**ADC Planning Consultation
Response from the Conservation Officer**

Application Number	BR/239/14/A
Address	Corner of West Street/Scott Street Bognor Regis PO21 1UH
Description	1 No illuminated (solar panel) pole mounted board sign.
Case Officer	Mrs J Chapman

Proposed Advertisement

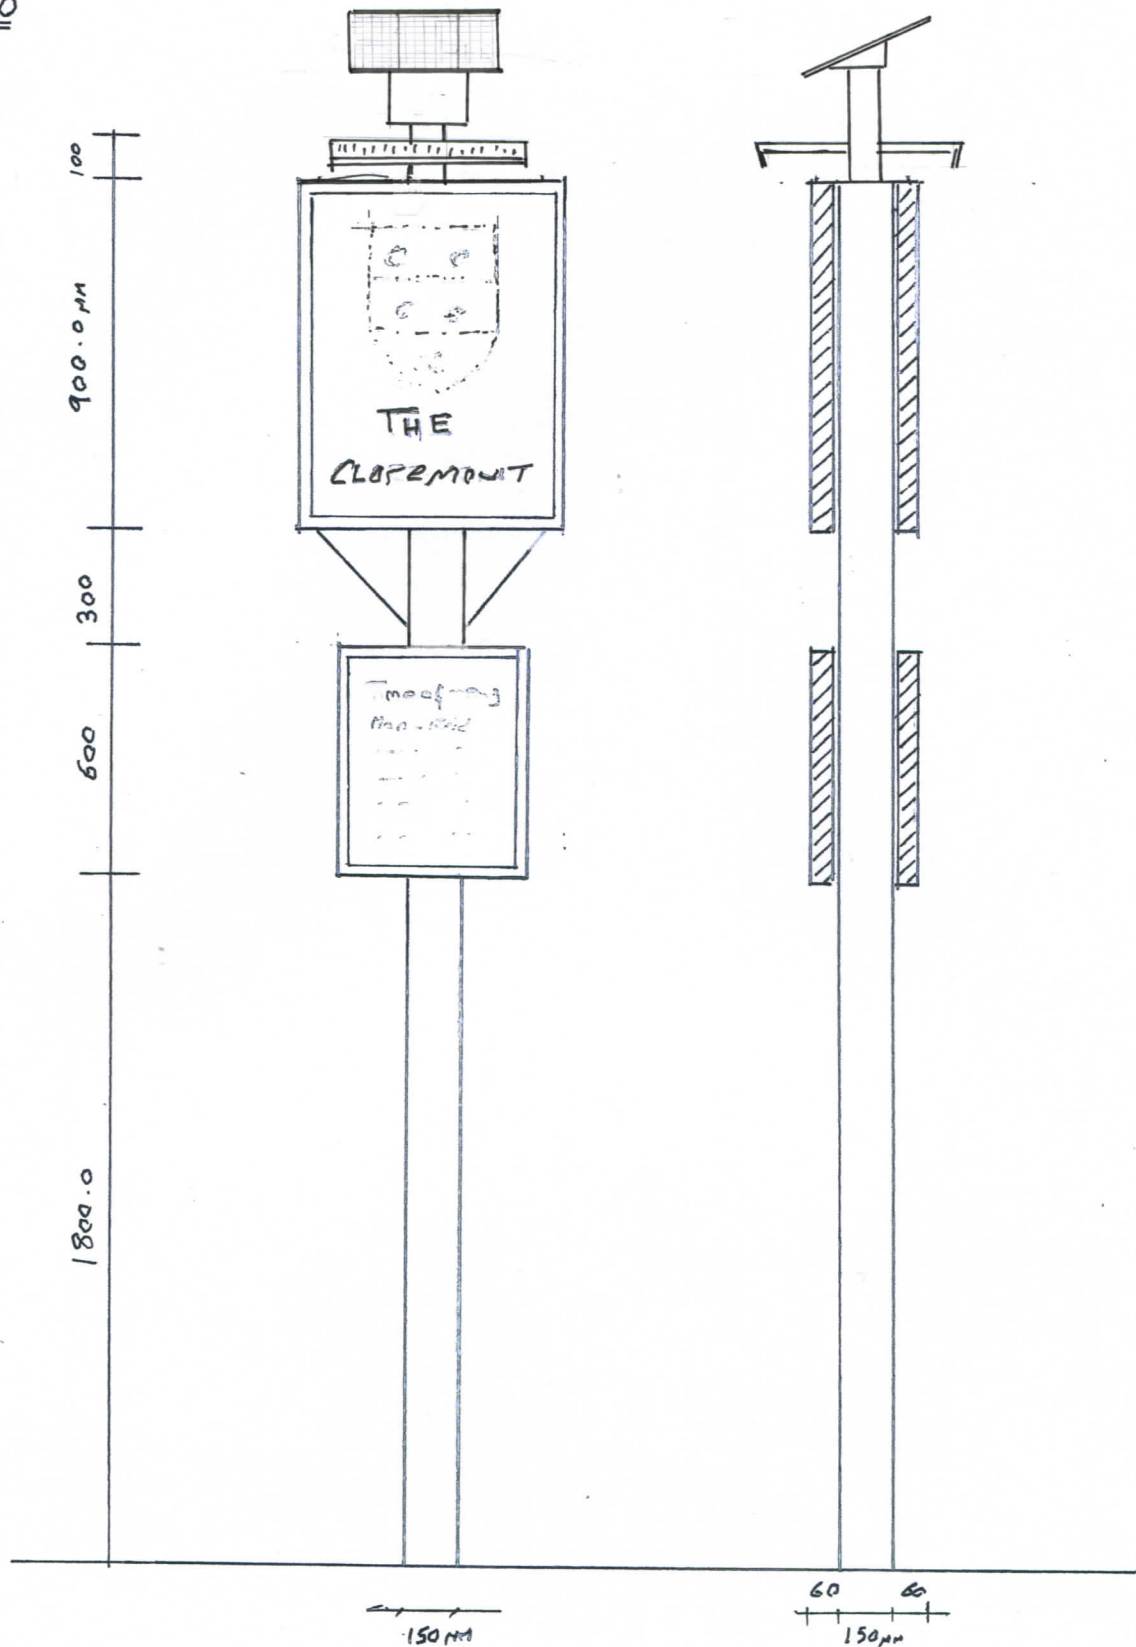
The proposal is for a pole mounted board sign within the Steyne and Waterloo Square Conservation Area. The location of the sign within the pavement at a section of the conservation area where a number of roads diverge is considered problematic. It is considered that the sign is not only complex with the introduction of the solar panels, it would add to the street furniture in the locality, and is of a size that it would be incongruous on the street scene.
